Your Ref: OWPC21005
Our Ref: WA/89/18/L 12-10-2018
Please ask for:
Zac Denton

Listed building consent for a replacement 1.19m high privacy screen, affixed to the existing 0.48m high dwarf wall giving a total height of 1.81m to North and West sides of patio.

9 Walberton Park Walberton

Drawing / Elevation
of replacement
Privacy Screen
above existing
dwarf Wall

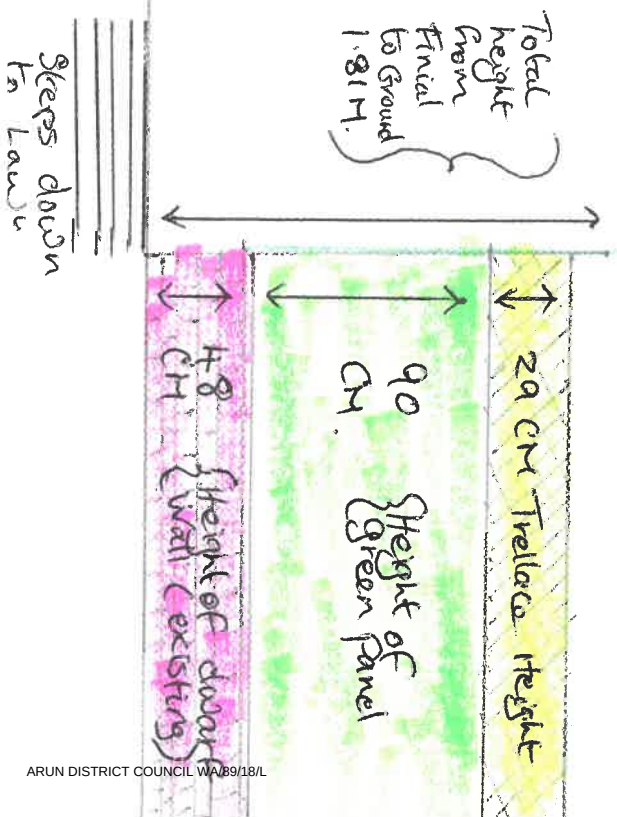
While I would not the replacement of what was there before (trellis/foliage), I do object to the screen that has already been erected. It is a metal, industrial type screen, higher than previously and is completely out of character with the rest of the Grade II listed property.*
